From: Nicola Moore
Sent: 19 January 2021 13:06
To: chris barrow
Subject: RE: AL/91/20/HH

1ST FLOOR PLAN
[As Prop^d]
[1:50]

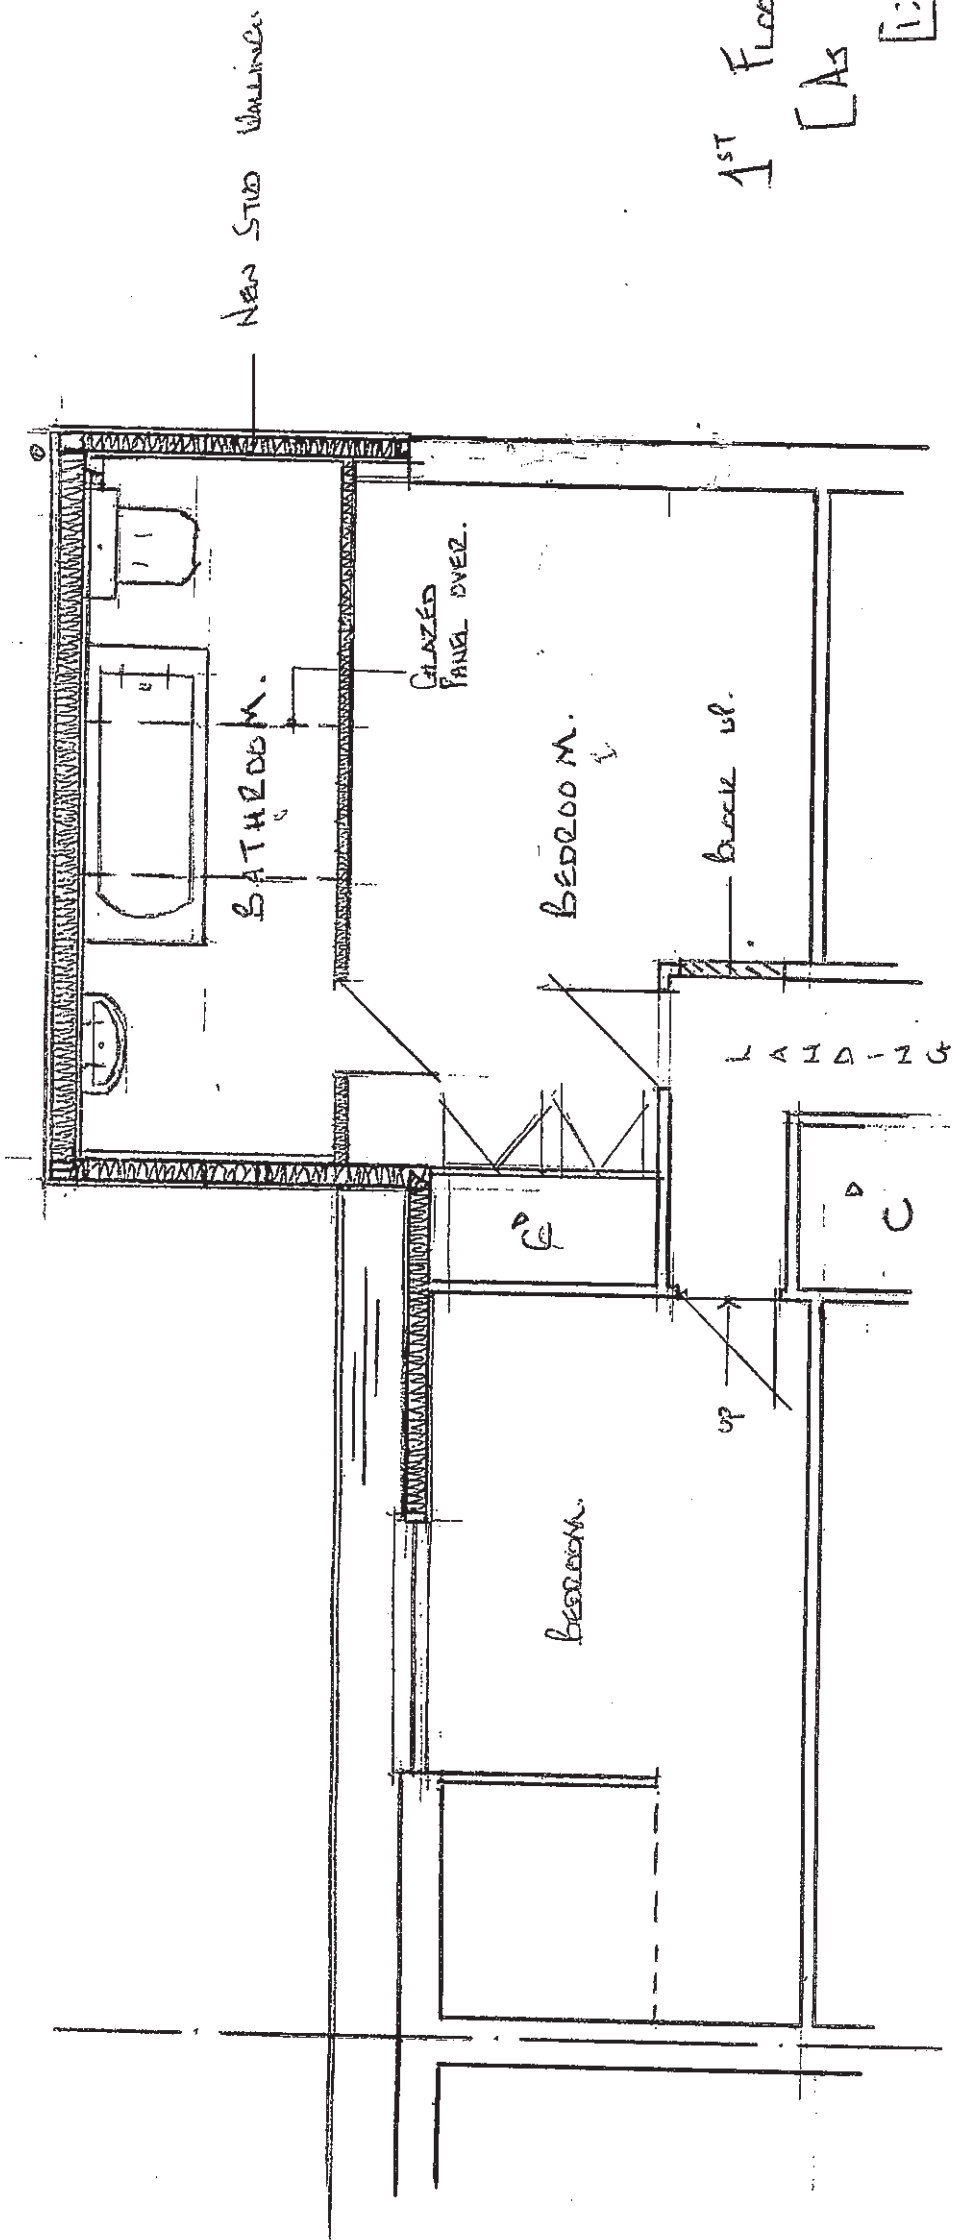
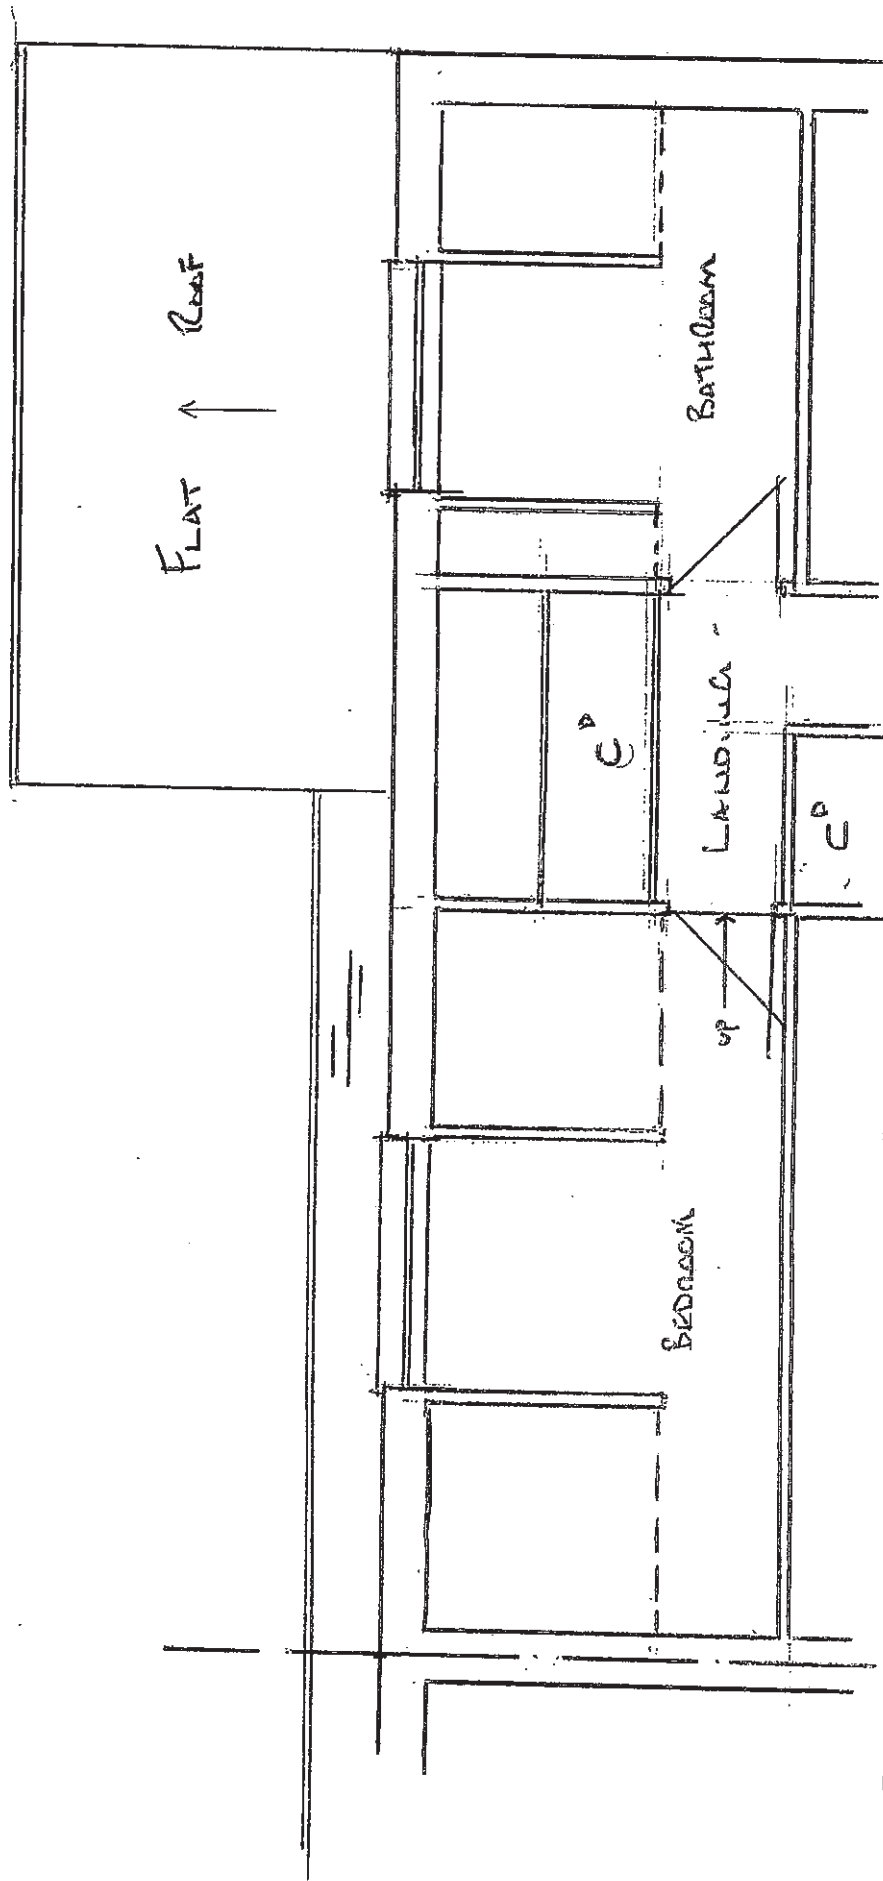
Please omit window from plan. I will do my end too.

The window is shown on the Proposed First Floor plan – please see below
